**To: All Staff**  
**From: Environmental Health**  
**Date: 2/27/2026**  
**Subject: AU-26-00002 Engle - Notice of Application**

SITE PLAN

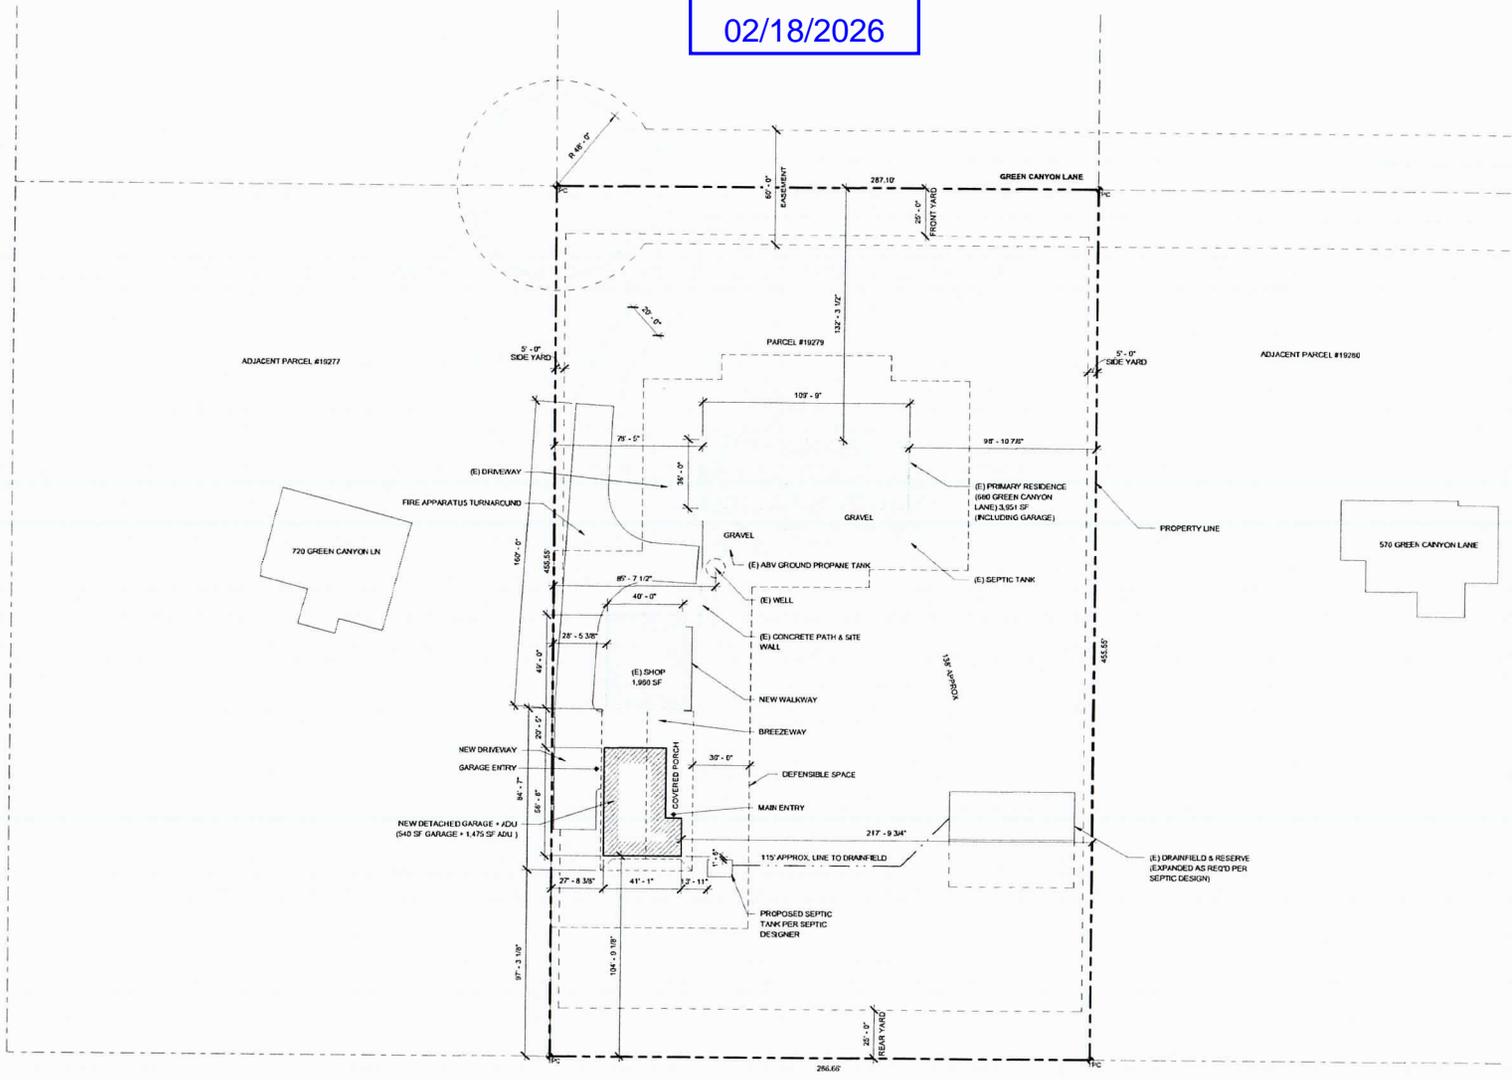
<b>Drinking Water</b>	<ul style="list-style-type: none"><li>• Requirements have been met. No comment.</li></ul>
<b>Wastewater</b>	<ul style="list-style-type: none"><li>• On-site sewage installation permit required; Type – Pressure System Expansion</li></ul>
